June 1, 2020

RE: Dwire Storage Yard Fil. No. 1 - Minor Subdivision Final Plat
DL Holdings, LLC
6547 N. Academy Blvd. #523, Colorado Springs, CO 80918

DWIRE STORAGE YARD FILING NO. 1

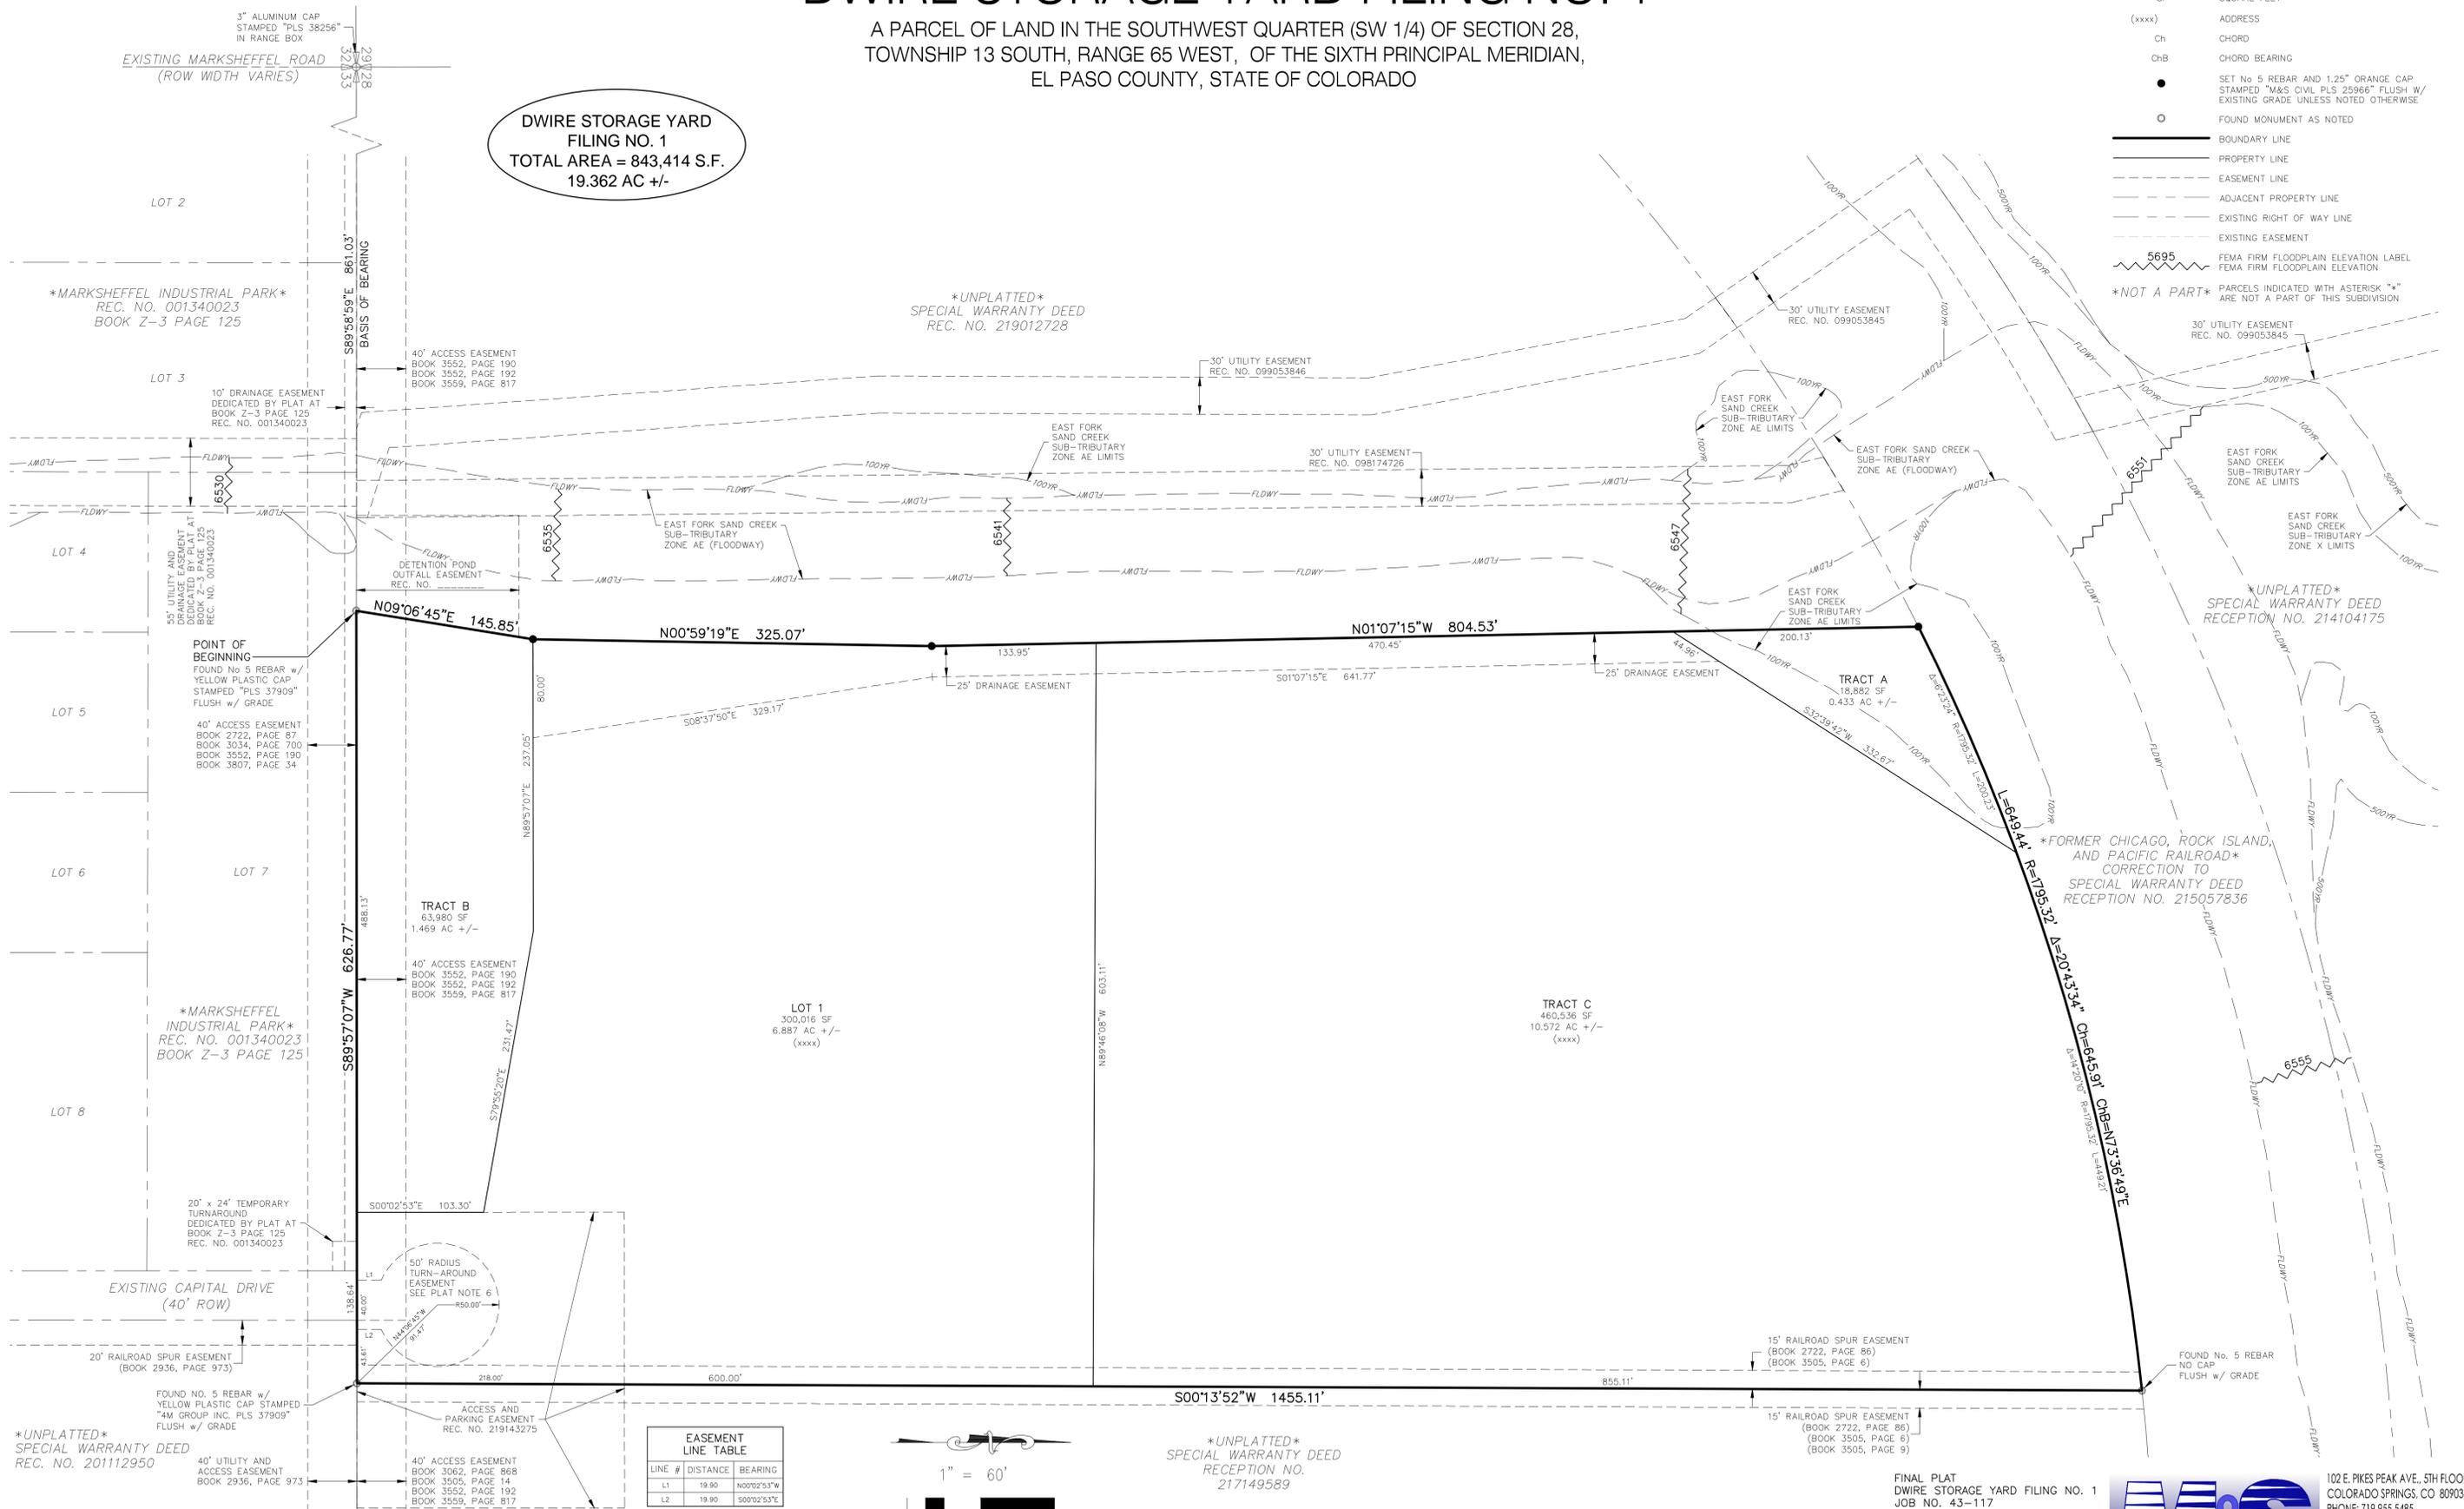
Address the additional
no-build/no-disturb area
(easement or tract) per plat and
FDR redlines.

No Build area has been
delineated within Tract C
